Subject: Re: Application Ref: LU/164/19/PL - 5 Arundel Road, Littlehampton

Environmental Health: Noise

Environmental Health:

PROPOSED FLOOR PLAN 102.9 Sqm - 1107 Sqft GIA

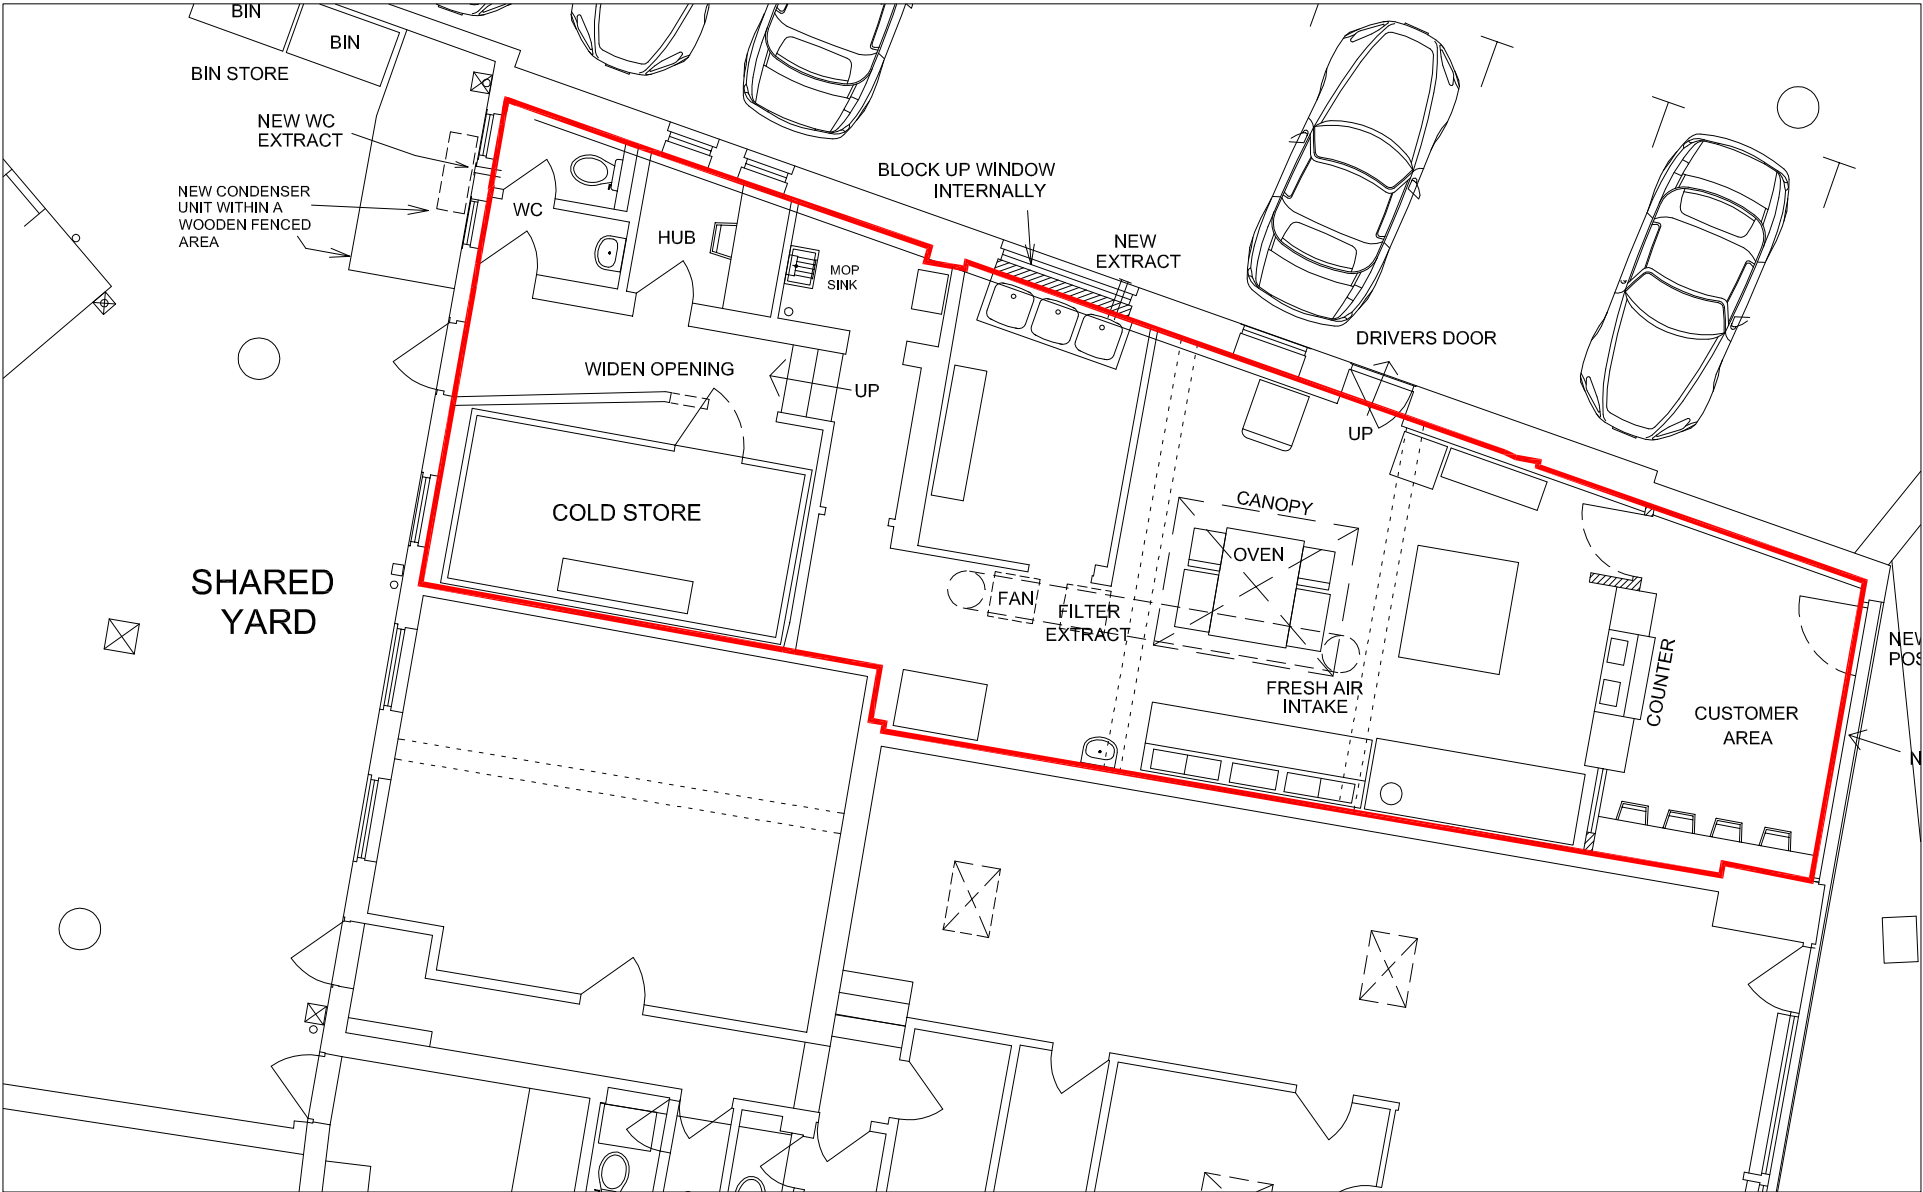
Please note that I am still not satisfied that the submitted internal layout is suitable in this case. Please do not hesitate to contact me again should I be able to provide any further assistance and please if you would, also copy all to Anita.

Studio Lack Architecture Studio Lack Ltd : 17 Beech Avenue : Chichester 01243 782 686 : nicholas.lack@live.com : PO19 3DR	5 Arundel Road, Littlehampton	Proposed Elevations 30/03/19 1/100 @ A3	Dwg 1915-07C
--	--	---	---------------------

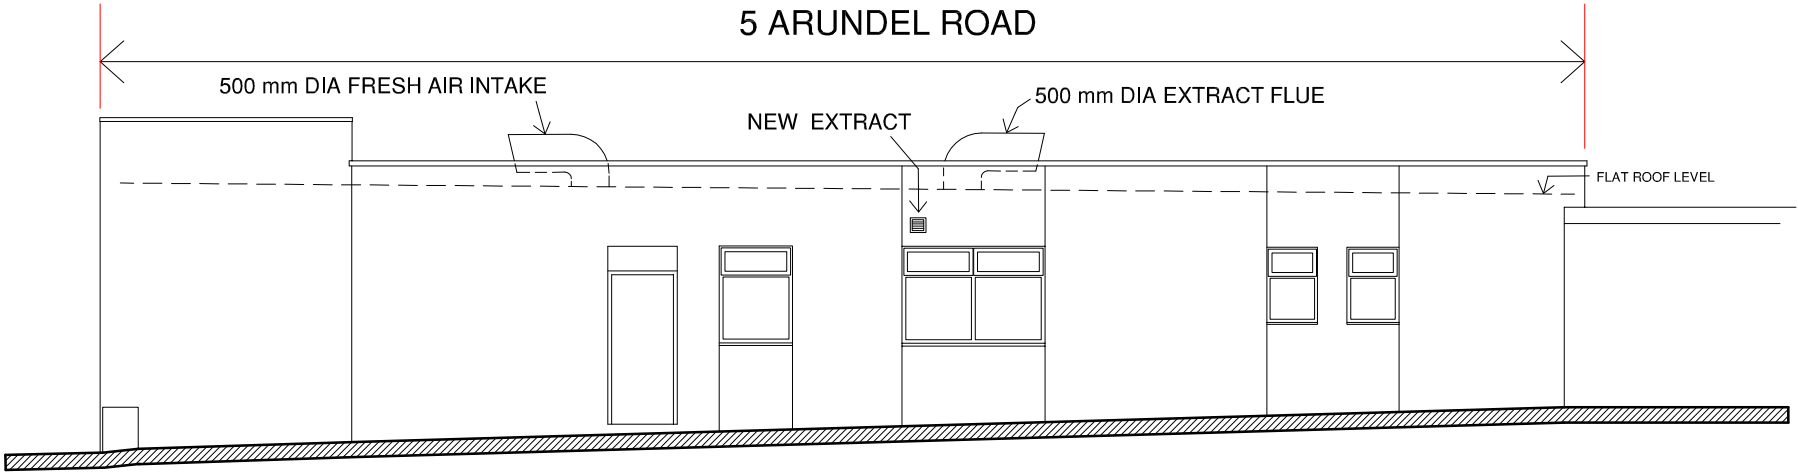
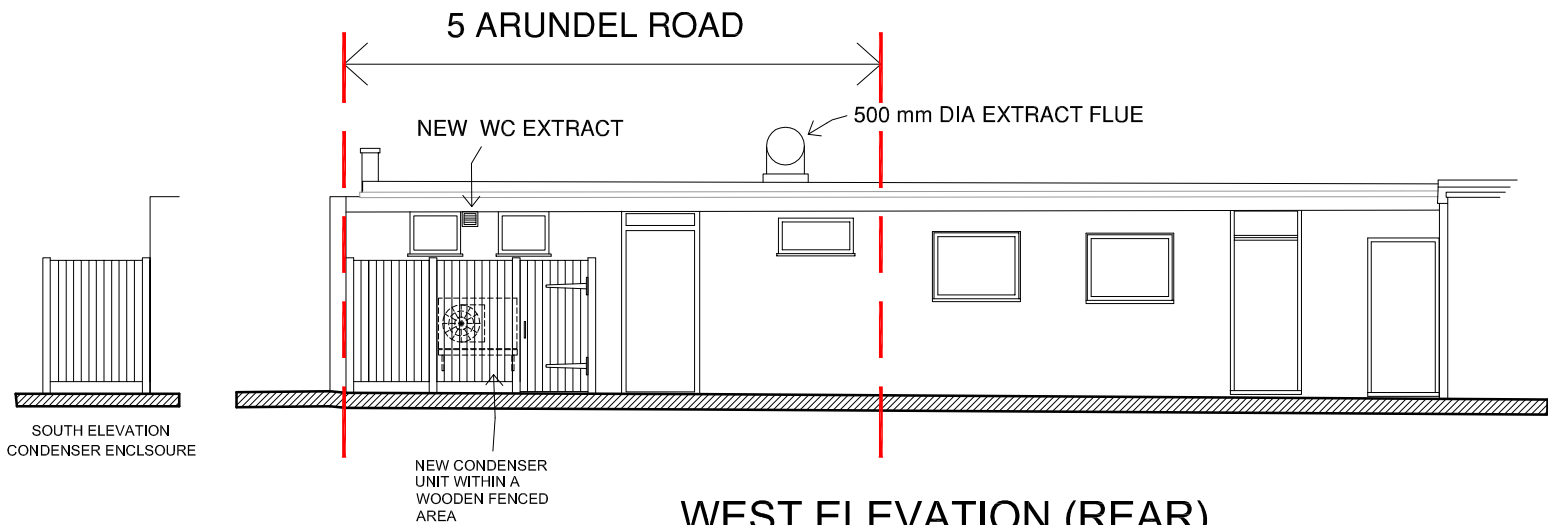
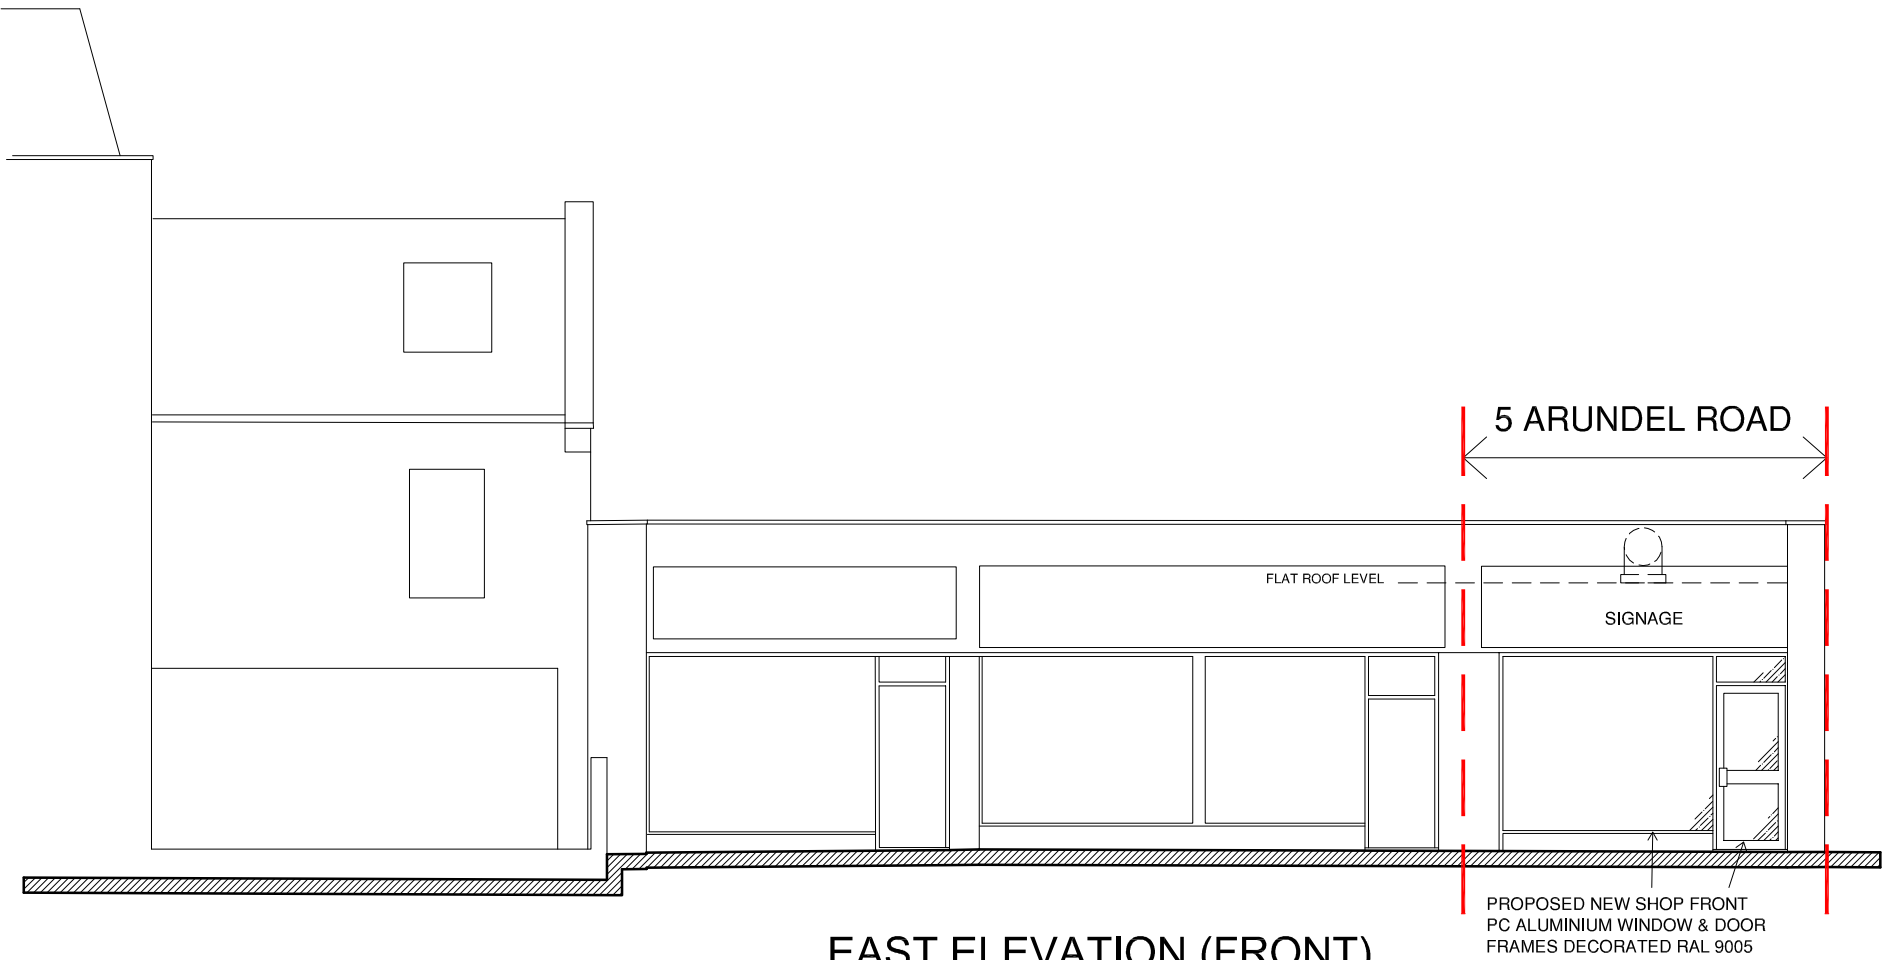
Unfortunately this report only considers noise from the condenser unit to the walk in chiller, whilst excluding other new noise sources particularly in respect of noise from the air intake and exit flue to the flat roof of this single storey building above the kitchen odour abatement system, but also extract ventilation to the kitchen sinks. Please would you request that the applicant also provides proper assessment of these areas, together with detail of any further mitigation measures that may be necessary

Odour Assessment: See Wyg Job Reference Number A113884, 4th Issue, 18th June 2019 and Defra Guidance on the Control of Odour and Noise from Commercial Kitchen Exhaust Systems, 2018. The proposed flue will discharge to the roof of this single storey business where it is surrounded by higher levels domestic residences. For this reason then I would dispute a dispersion Score of '10 – Moderate' instead applying the Rating '20 – Very poor,' particularly since this faces sensitive rooms of that home to the immediate north of the development. I would also Rate the size of this kitchen as 'Medium – 5 rather than Small – 1' and the type of cooking as '4 – Medium.' I agree with the Rating of 10 for the proximity of receptors, which leads me to the overall Odour Risk Assessment of 37 and the need for a 'Very High' level of odour control. Alongside baffle filters detailed then specification to be given for the type of prefilter to be provided as well as clarification as to a 0.4 second retention time through the activated carbon filters.
